**WEST SUSSEX COUNTY COUNCIL
PLANNING SERVICES CONSULTATION**

SUBJECT: WA/88/17/PL- External alterations including replacement windows & doors to create new entrance, cladding of external walls & creation of seating area to facilitate new operator (KFC) together with provision of drive-thru lane (use class A3/A5).

Little Chef Restaurant, Arundel Road, Walberton, BN18 0SB

**Advice
Objection**

PROPOSED GENERAL
ARRANGEMENT PLAN

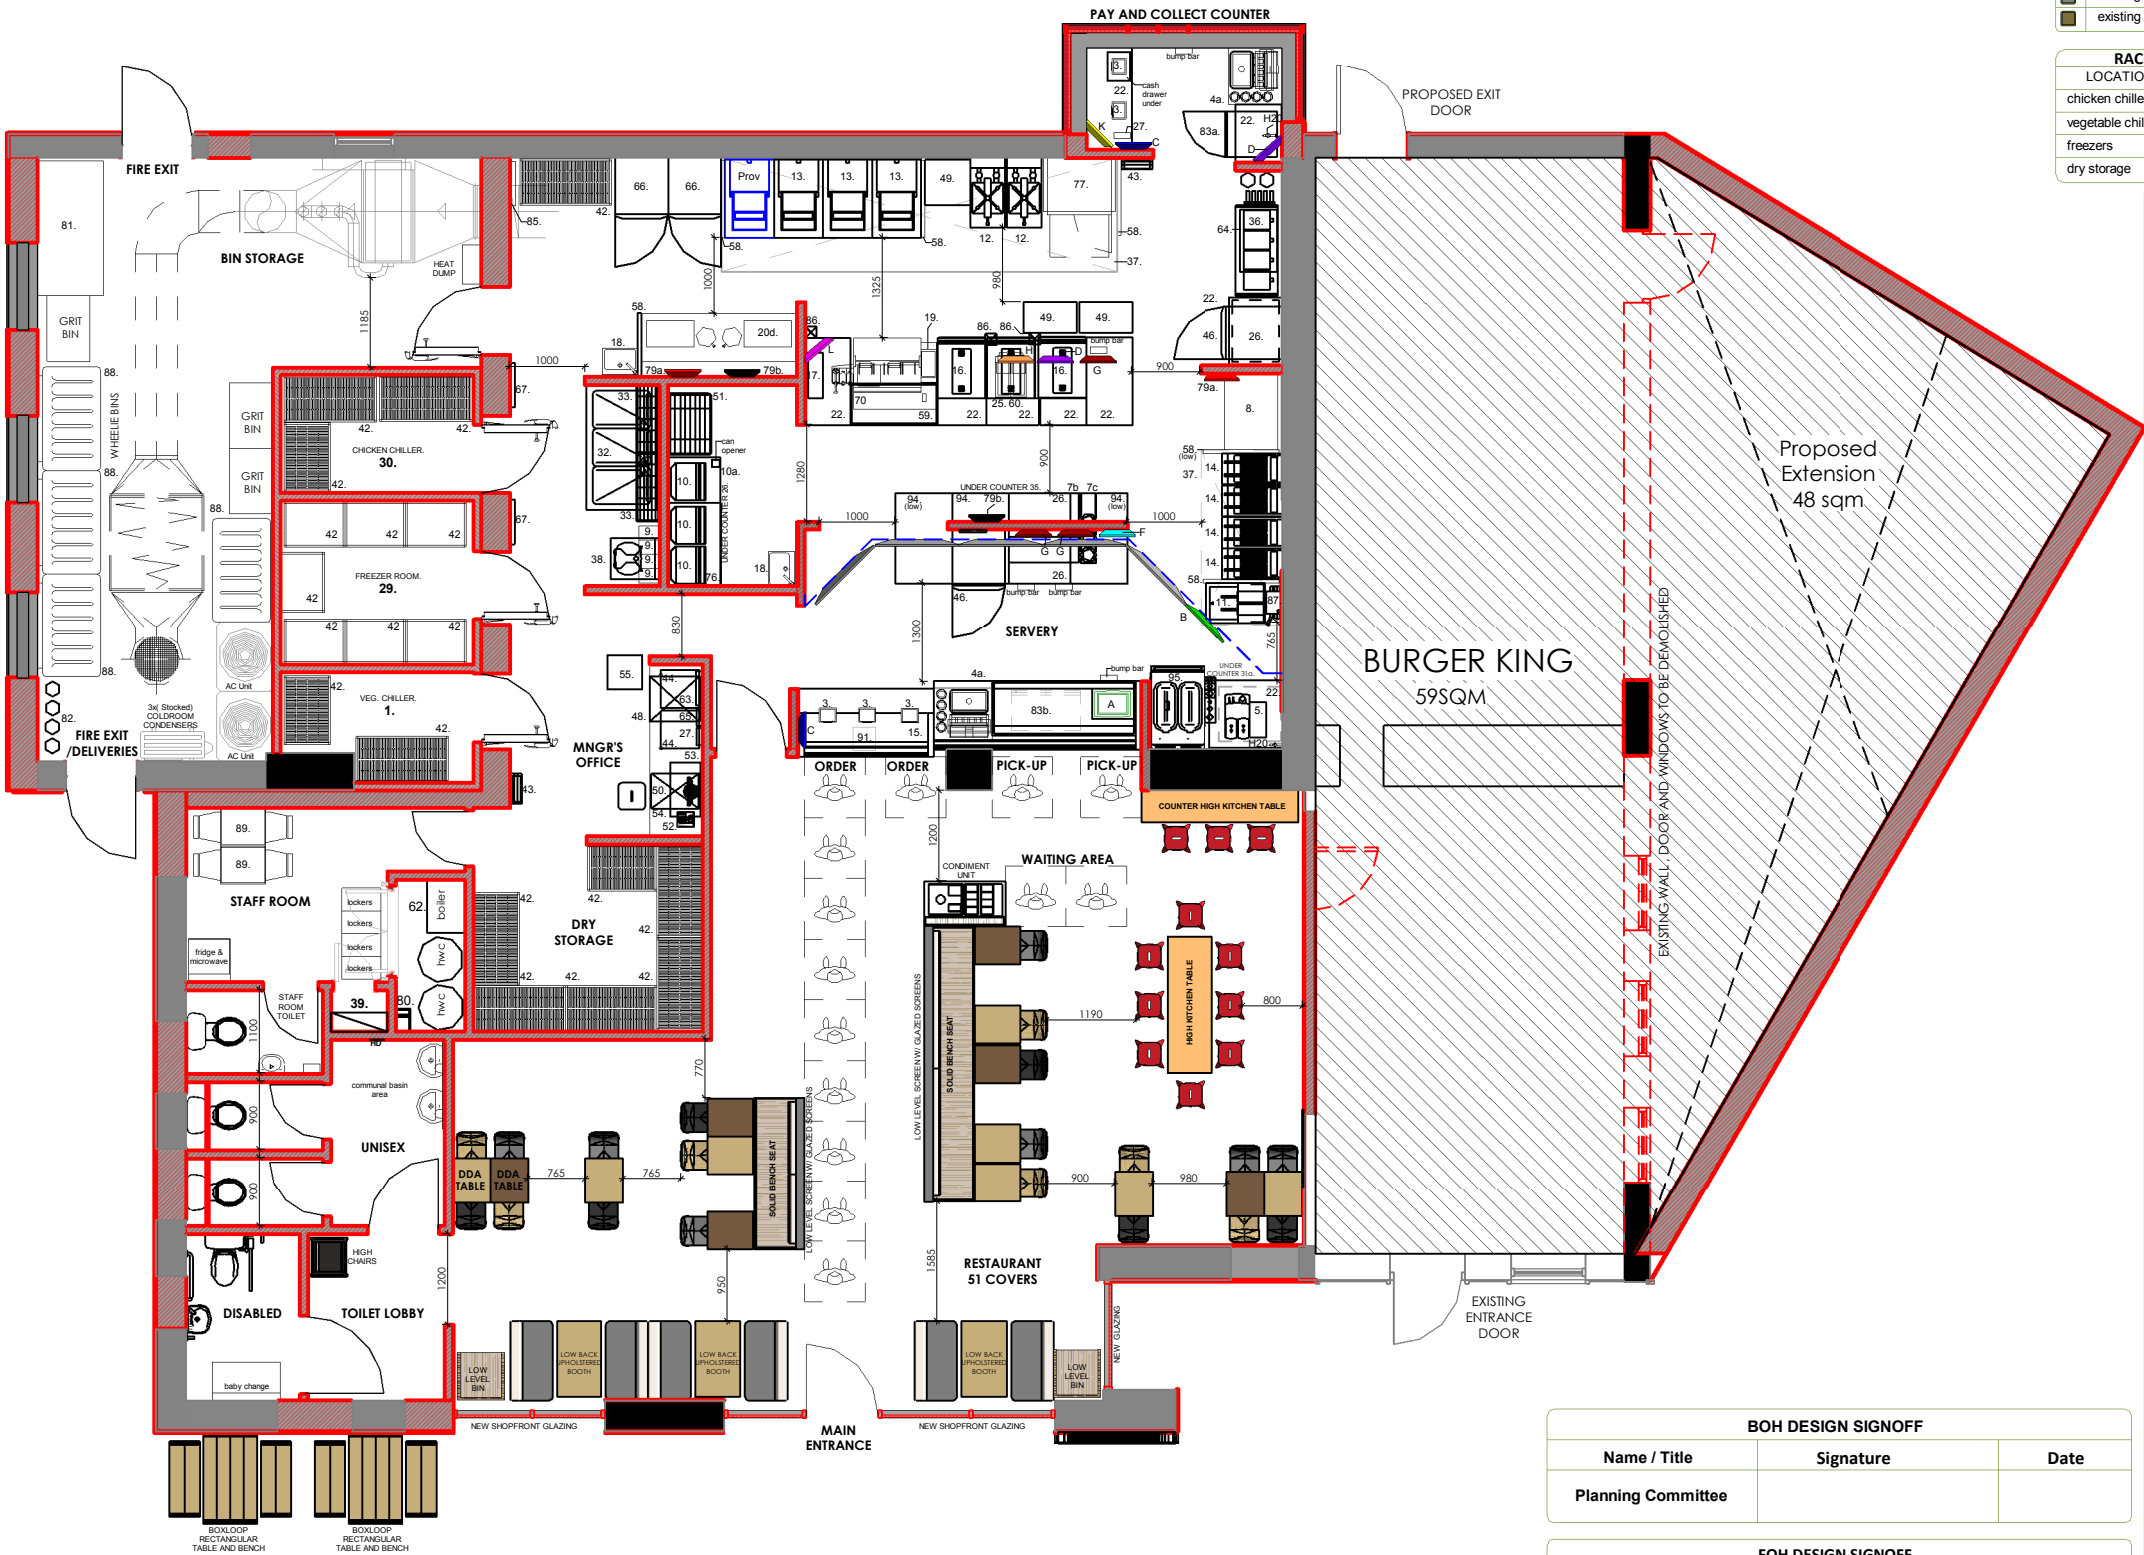
From observation of the plans, the proposal appears acceptable. Adequate space has been provided for vehicles to navigate into and through the drive through lane. Access road widths are sufficient for the likely demand; given the one way nature of these roads it is not anticipated that the necessity for two vehicles to overtake one another will arise frequently in this location.

Disabled parking bays have been relocated to the east of the site. There should also be a 1200mm wide safety zone at the vehicle access end of each bay to provide boot access or for use of a rear hoist. In off-street parks, bays should be marked with yellow lines and a yellow wheelchair symbol within the parking space. A sign or, if appropriate, signs should be provided at the entrance to the car park to direct disabled motorists to designated parking spaces which, if the car park is not under cover, should also have raised signs at the head of the reserved bays.

The car parking spaces are to measure 2.4 x 4.8m in order to adequately cater for an average sized vehicle and a space of 6m is required to the rear of the parking space to allow vehicles to manoeuvre into and out of the spaces.

Tactile paving is present at key locations within the site to encourage pedestrians to cross where it is safe to do so and footway widths are acceptable in line with the Department for Transport's Inclusive Mobility documentation.

Based on the information submitted there would be no concerns with this application from a highway point of view, a condition should be attached to secure the revisions to the parking spaces and layout of the new fast food lane.

No part of the development shall be first used until the lanes and parking areas serving the proposed have been constructed, surfaced and drained in accordance with plan 217052 - A000.
